City of Portland, Maine - Building or Use Permit Application

Permit No: 03-0061	Issue Date: JUN 18 2003	CBL: 221 A005001
-----------------------	----------------------------	---------------------

Location of Construction: 138 Stroudwater Rd	Owner Name: Buxton Anthony W &	Owner Address: 138 Stroudwater Rd CITY OF PORTLAND	Phone: 222-A-31 207-772-8854
Business Name: n/a	Contractor Name: Home Improvement LLC	Contractor Address: PO Box 252 Westbrook	Phone:
Lessee/Buyer's Name n/a	Phone: n/a	Permit Type: Additions - Dwellings	Zone: R-2
Past Use: Single Family	Proposed Use: Single Family / Add 20' x 30' second floor bedroom	Permit Fee: \$380.00	Cost of Work: \$51,000.00
		CEO District: 3	
Proposed Project Description: Add 20' x 30' second floor bedroom		FIRE DEPT: N/A <input type="checkbox"/> Approved <input type="checkbox"/> Denied Signature:	INSPECTION: Use Group: R-3 Type: SB BOCA 99 Signature:
		PEDESTRIAN ACTIVITIES DISTRICT (P.A.D.) Action: <input type="checkbox"/> Approved <input type="checkbox"/> Approved w/Conditions <input type="checkbox"/> Denied Signature: Date:

Proposed Use: Single Family / Add 20' x 30' second floor bedroom - & addition	Proposed Project Description: Add

HOME IMPROVEMENT, LLC.		Elevations	Addition
PO Box 252 Westbrook, Maine 04098 207 838-2532	Donald Hoglund, SR. President	Plan For:	1 4
		Drawn by:	Wayne Paradis
			Jan. 20, 2003

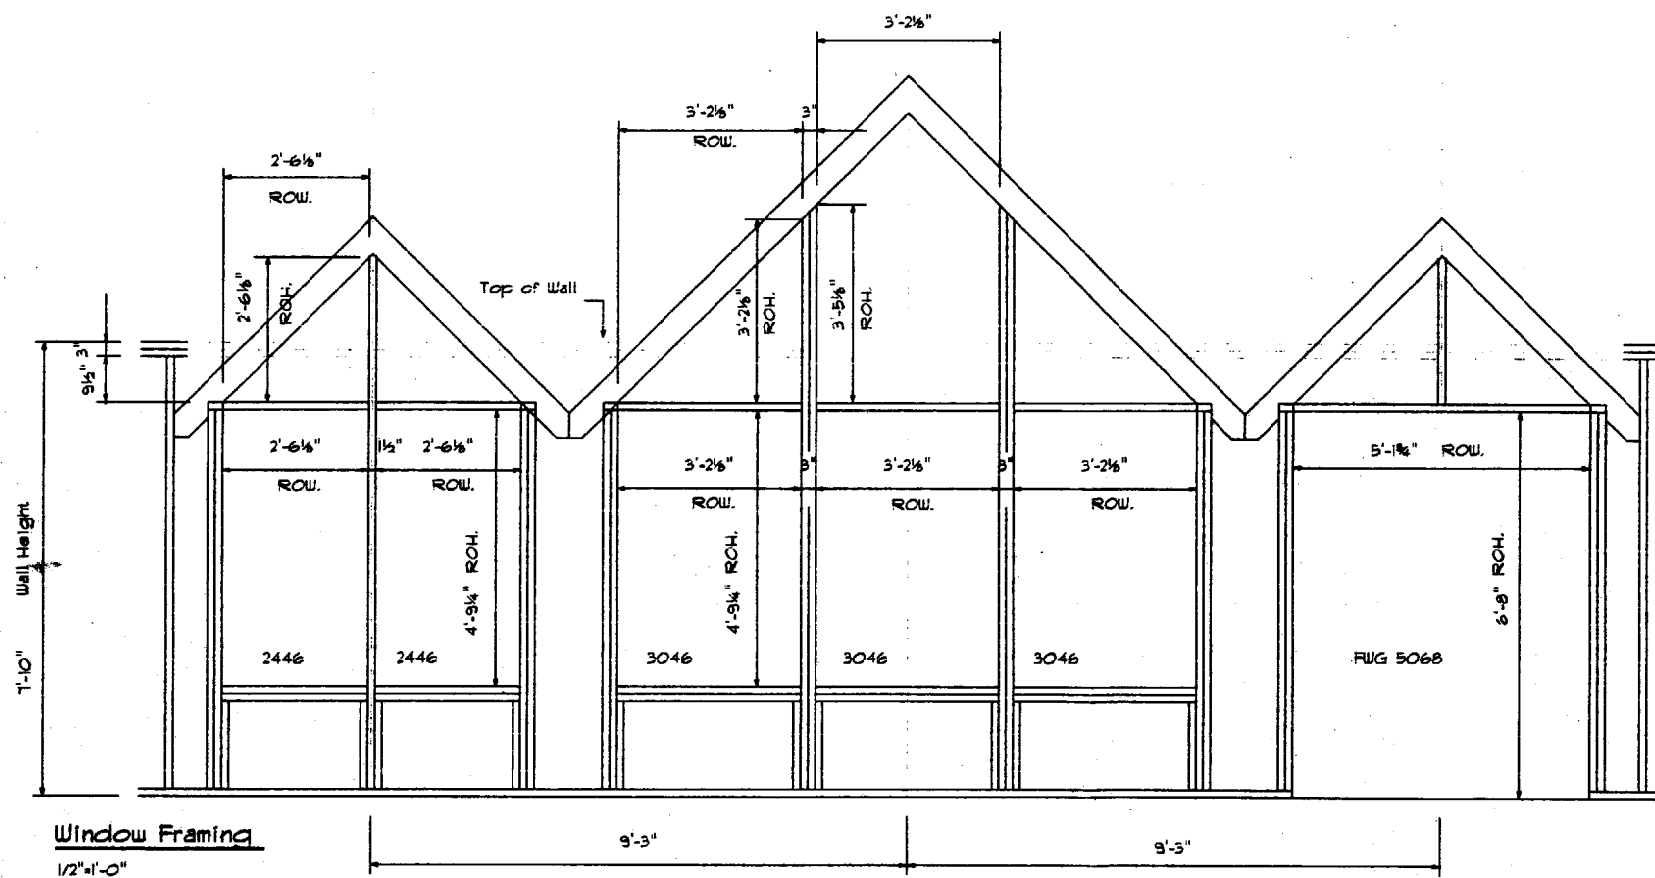
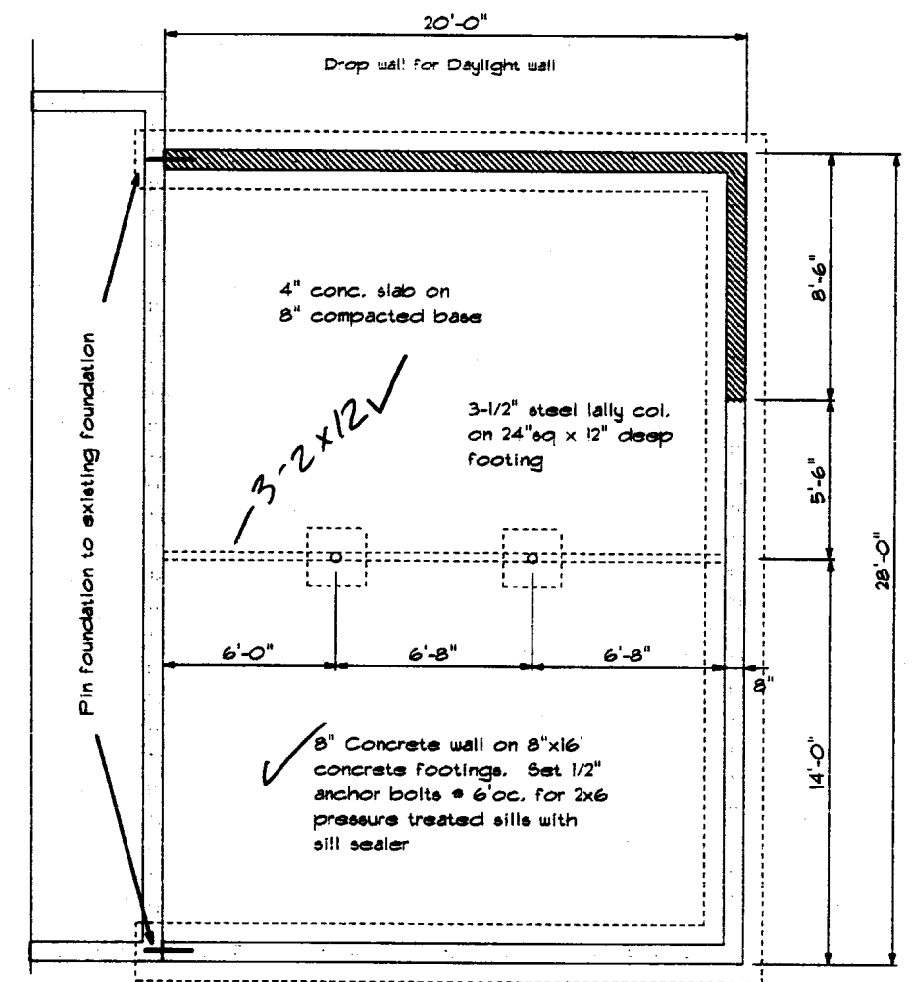
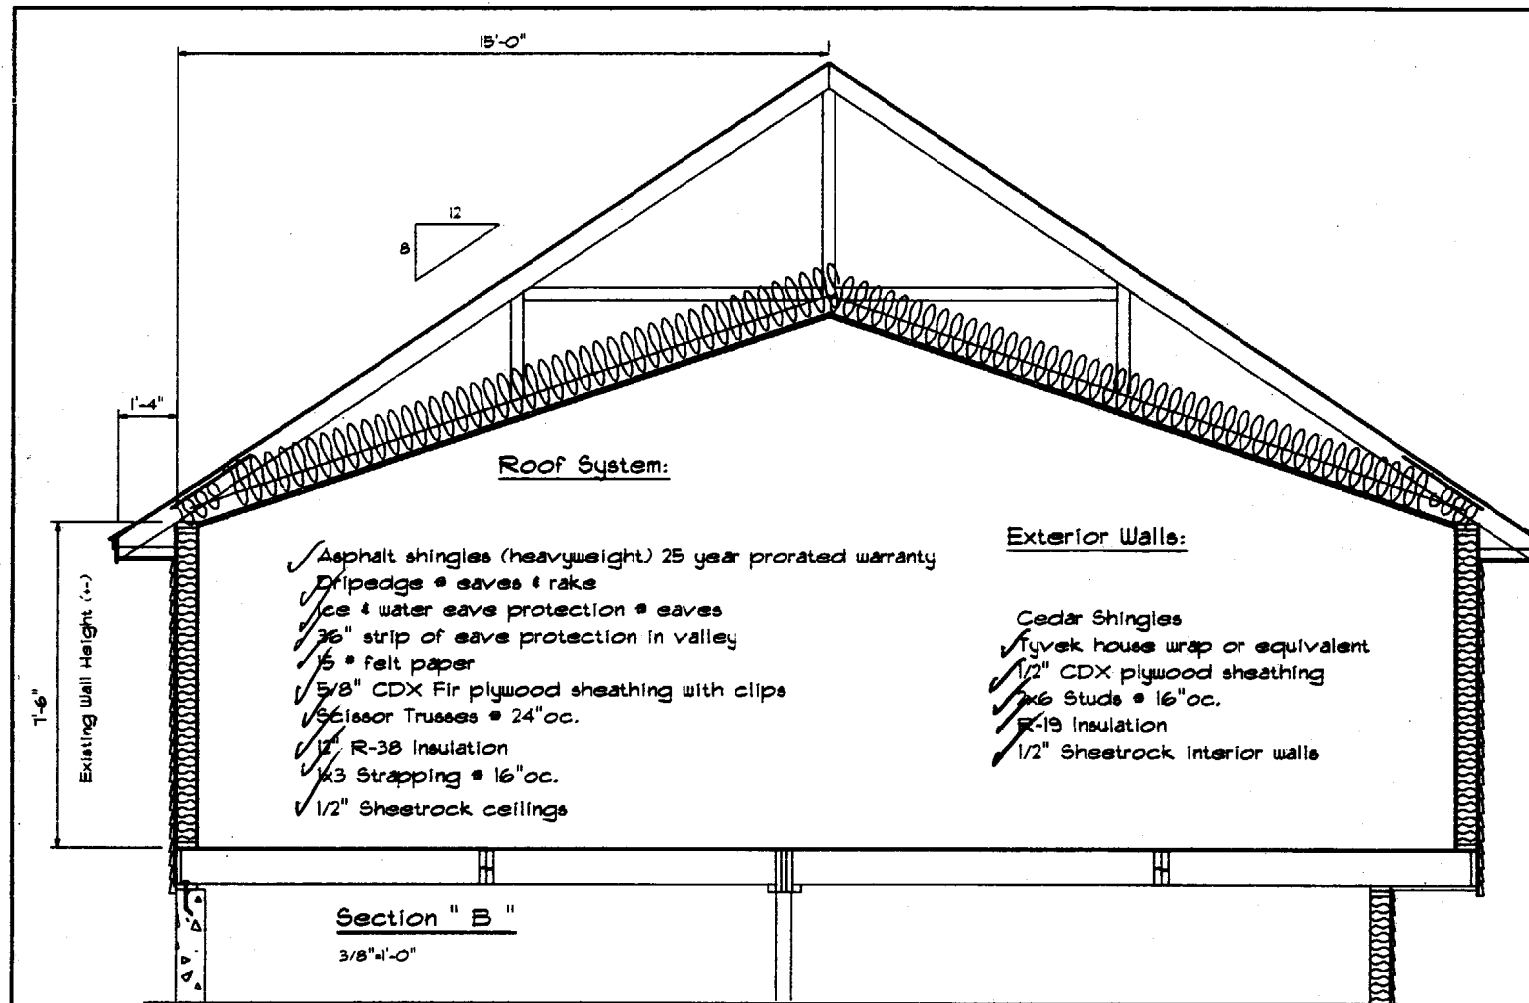
<b>Dept:</b> Zoning	<b>Status:</b> Approved with Conditions	<b>Reviewer:</b> Marge Schmuckal	<b>Approval Date:</b> 06/13/2003
<b>Note:</b> received from Tammy 2/24/03 2/25/03 back to Tammy - I need scaled drawings to check the heights. 6/12/03 received permit back from T.M. with scaled plans - height ok			<b>Ok to Issue:</b> <input checked="" type="checkbox"/>

2/25/03 back to Tammy - I need scaled drawings to check the heights.

6/12/03 received permit back from T.M. with scaled plans - height ok

HOME IMPROVEMENT, LLC. PO Box 252 Westbrook, Maine 04098 207 838-2532		Section "A" Addition	
		Plan For: Tony Buxton	4 4
Donald Hoglund, SR. President		Drawn by:	Wayne Paradis
		Jan. 20, 2009

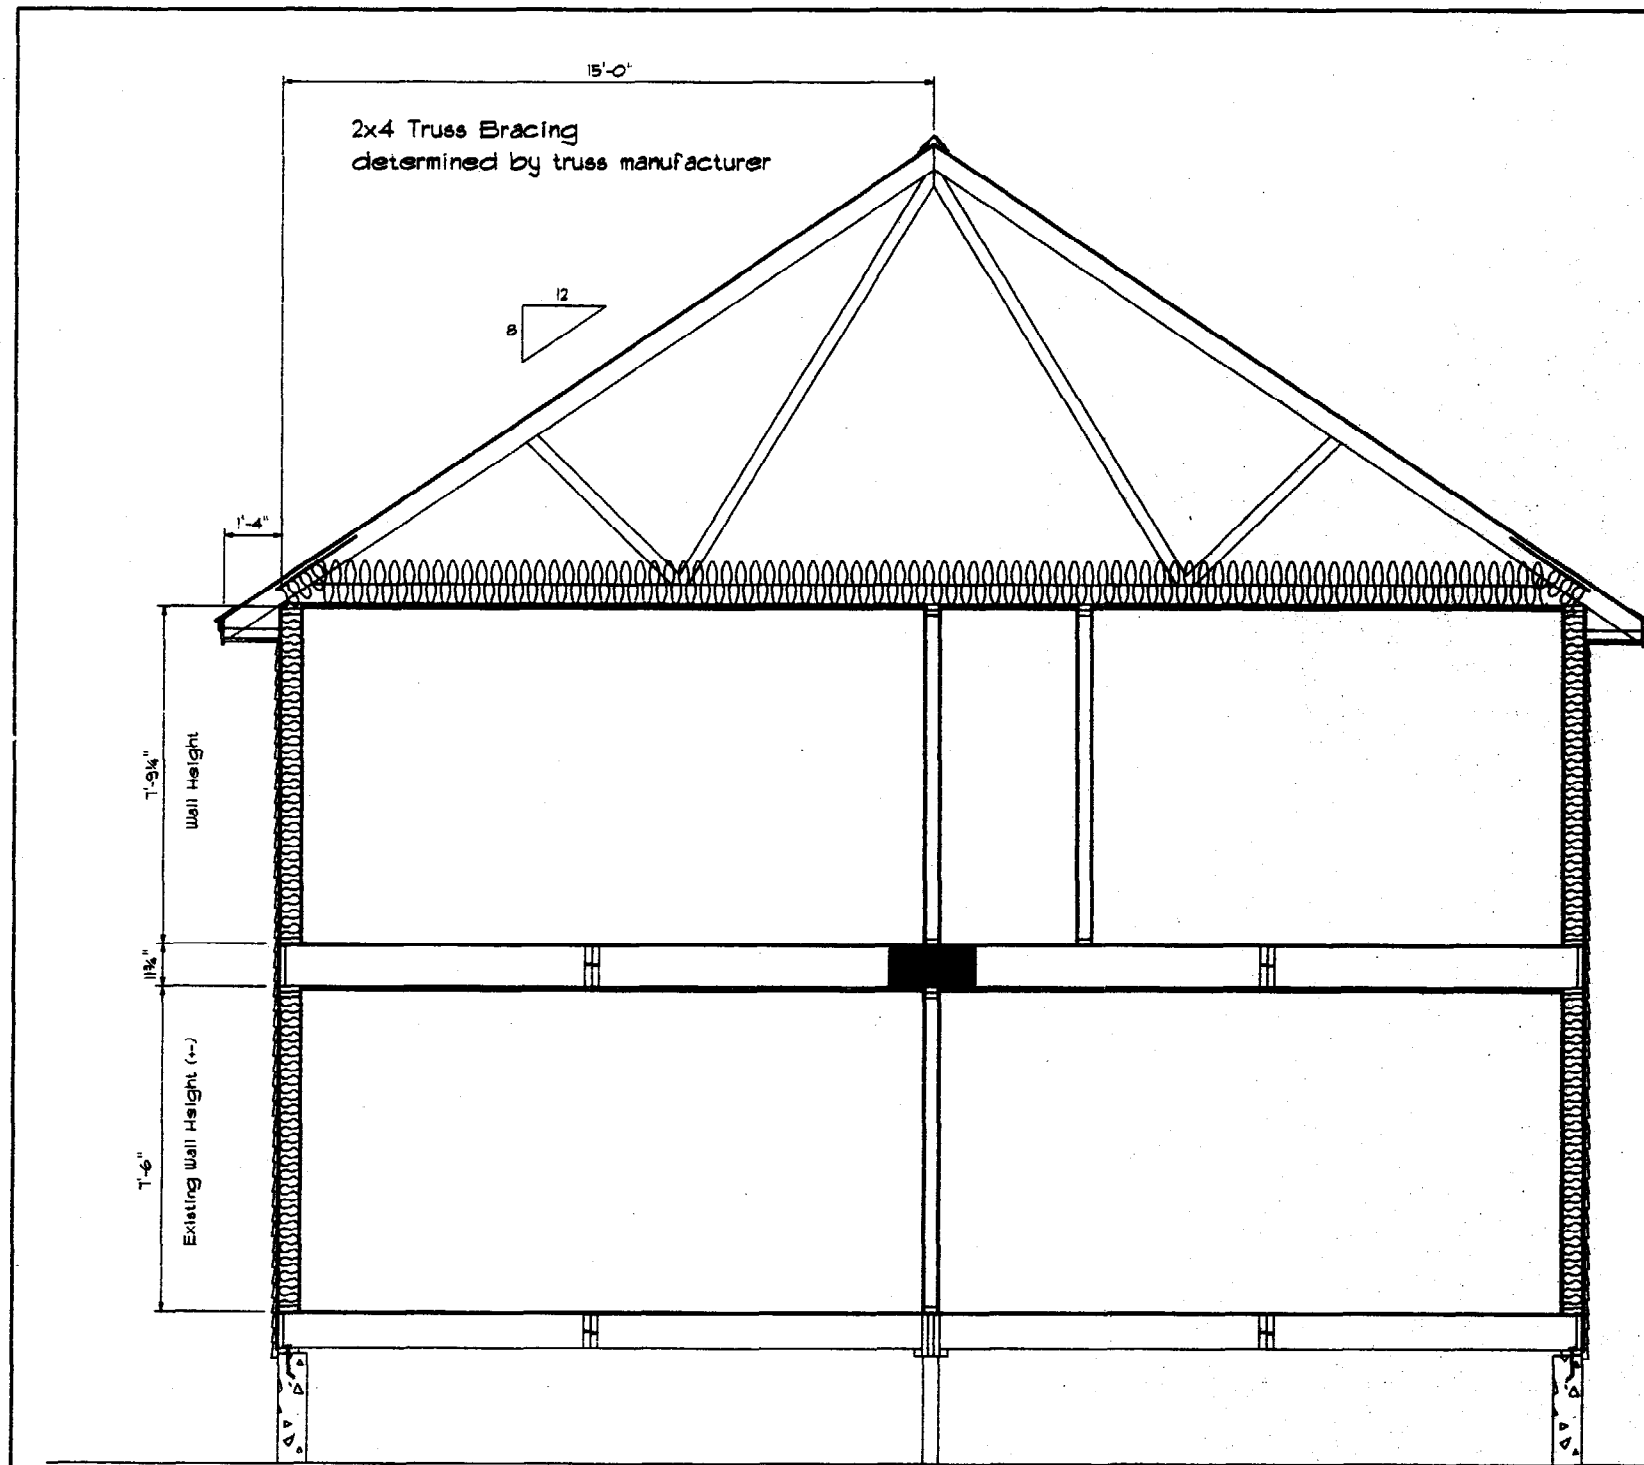
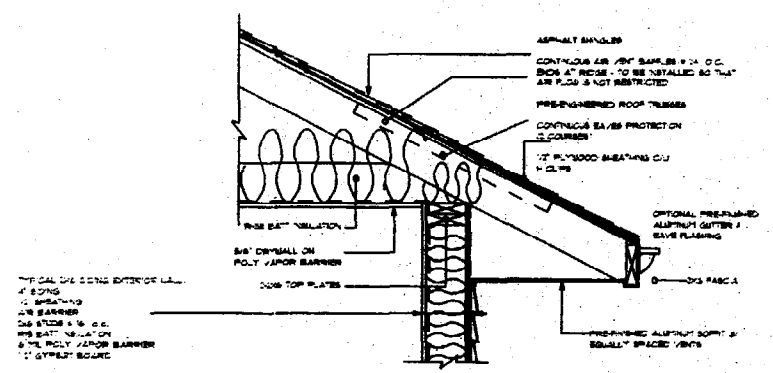
2/21/03-tm: Plans very incomplete - need the following: need header info, floor framing of addition, 2nd floor framing, smoke det. Locations, chimney clearances, stair details, truss specs. guardrail details, egress window specs, safety glazing in baths, balcony construction and area under balcony, cantilever of floor system?, dormer framing details

6/11/03-tmm: rec'd new plans from Don Hoglund - reviewed - still a few code issues - will meet on 06-18-2003 to review w/builder and issue.
